June 30, 2015

FEMA LOMC Clearinghouse
Attention: LOMR Manager
847 South Pickett Street
Alexandria, VA 22304-4605

**RE: Case No. 15-06-0805R
Response to Request for Additional Information**

Geom: PINO ARROYO - EXST 2
RS = 2183.63

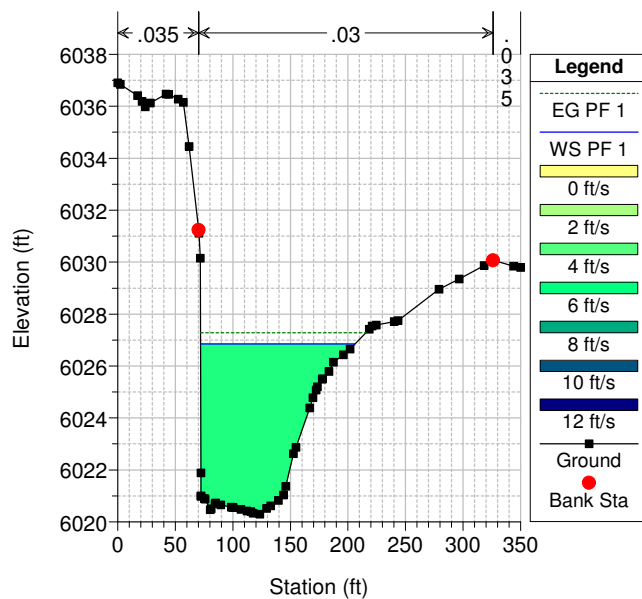
- d. *"Cross-Sections 2183.63 and 2200 are intersecting each other. Similarly, Cross-Sections 1942.35 and 1948.66 are also intersecting. Cross-Section 1948.66 is shown on the work map but not included in the hydraulic analysis. Please ensure that all cross-sections used in the hydraulic model are shown on the work map and do not intersect each other."*

I shortened Cross Section 2183.63 by 1' to make sure it doesn't overlap with Cross Section 2200. Thank you for bringing that to my attention.

RS = 1873.47

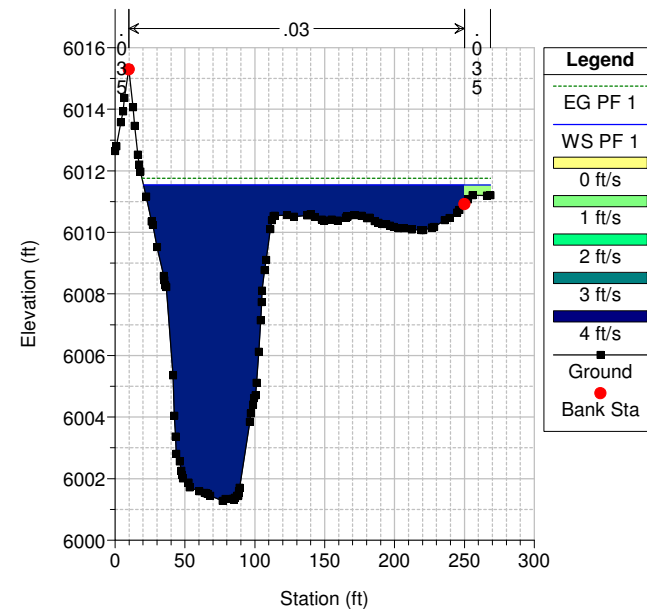
4. *"Our review revealed that the 1-percent-annual-chance Base Flood Elevations (BFEs) are higher than the end points of Cross-Sections 1873.47, 1086, and 1054.4 in the submitted existing conditions HEC-RAS hydraulic computer model and Cross-Sections 1086 and 1054.4 in the submitted proposed conditions HEC-RAS model along Pino Arroyo. The use of vertically extended cross-sections might both overestimate the BFEs and underestimate the width of the base floodplain. This issue was raised in our letter of January 7, 2015; however, no concrete justification was provided in this regard. Please revise the cross-section geometry coordinates so that the end points of all cross-sections are equal to or extend higher than the corresponding BFEs, or provide documentation that quantifies the amount of split flow that would occur if the cross-sections were not extended, and the extent of all flow breakouts."*

In the existing condition I extended Cross Section 1873.47 125' to the south. I also extended Cross Sections 1878.66, 1887.76, and 1891.58 at gradually decreasing increments to allow for a smoother transition between the Cross Sections.

PINO ARROYO - EXISTING CONDITIONS Plan: Plan 15 4/28/2015
Geom: PINO ARROYO - EXST 2

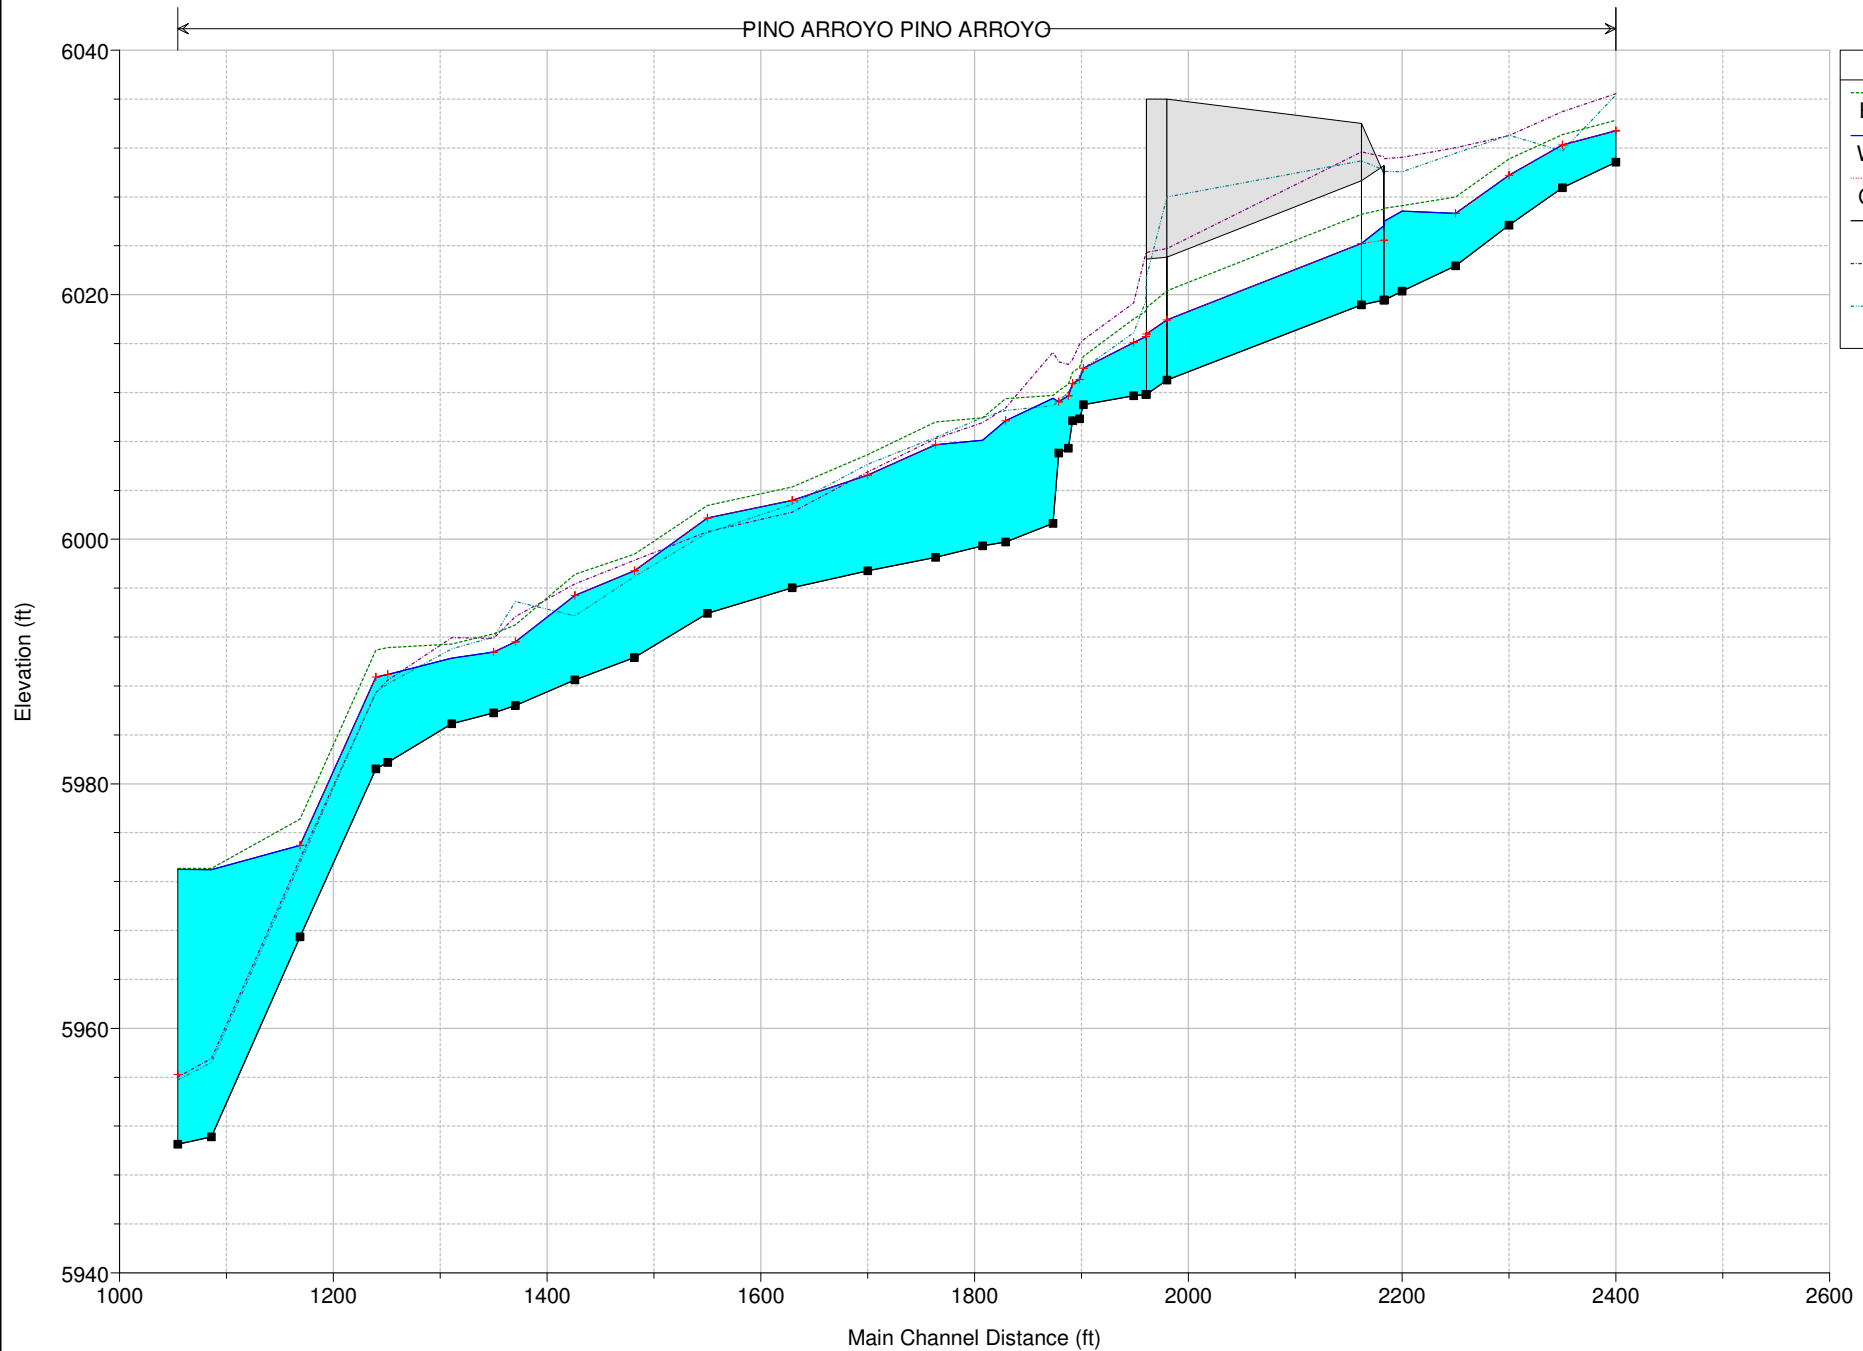
5. *"Our review revealed that the submitted existing and proposed conditions hydraulic models were run using the mixed flow regime. FEMA accepts base floodplain boundary delineations based on supercritical flow depths only for concrete-lined engineered channels. Because the existing and proposed channel is not concrete lined, critical depth is the minimum depth permissible to map the base floodplain boundary delineations along this reach. This issue was raised in our letter of January 7, 2015; however, no concrete justification was provided in this regard. Please revise the hydraulic analysis for this portion of the channel using subcritical modeling, or provide an explanation along with a concrete justification for not using subcritical modeling."*

To check my suppositions, I reran the existing condition using subcritical flow regime. I have included the results with this letter (see attached) as a reference to explain why a subcritical flow regime is incorrect for this site. **The existing conditions model in the CLOMR report is still the mixed flow regime.**

Please note that for most of the run the subcritical regime calculates a Fruede number of 1.0. I believe these areas are most likely in a supercritical condition, either because it is in a concrete-lined rundown, a concrete box culvert, or it is a supercritical natural channel. (The natural channel is in a highly erosive state.)

Cross Sections 1168.85, 1239.93, and 1251.03 cover the existing concrete rundown on the side slopes of the Pino Dam. This is a 6'± deep, 20' bottom-width, trapezoidal concrete channel at a 20% longitudinal slope. Manning's equation shows this portion of the arroyo as supercritical. (See attached.) When using the subcritical flow regime these cross sections all model as overtopping. I don't believe overtopping subcritical flows are the true existing condition, since there is no sign of erosion behind the edges of the rundown. (Even if it were actually subcritical, the overtopping flows would all be contained by the dam pool. They would not harm other nearby structures.)

The subcritical flow regime provides an analysis that is inconsistent with other calculation methods and visual evidence in the field. A supercritical flow regime would not take into account portions of the natural channel that are subcritical. The mixed flow regime results are consistent with all of this information.

The subcritical flow regime is inappropriate for the existing condition model. The mixed flow regime should be used.
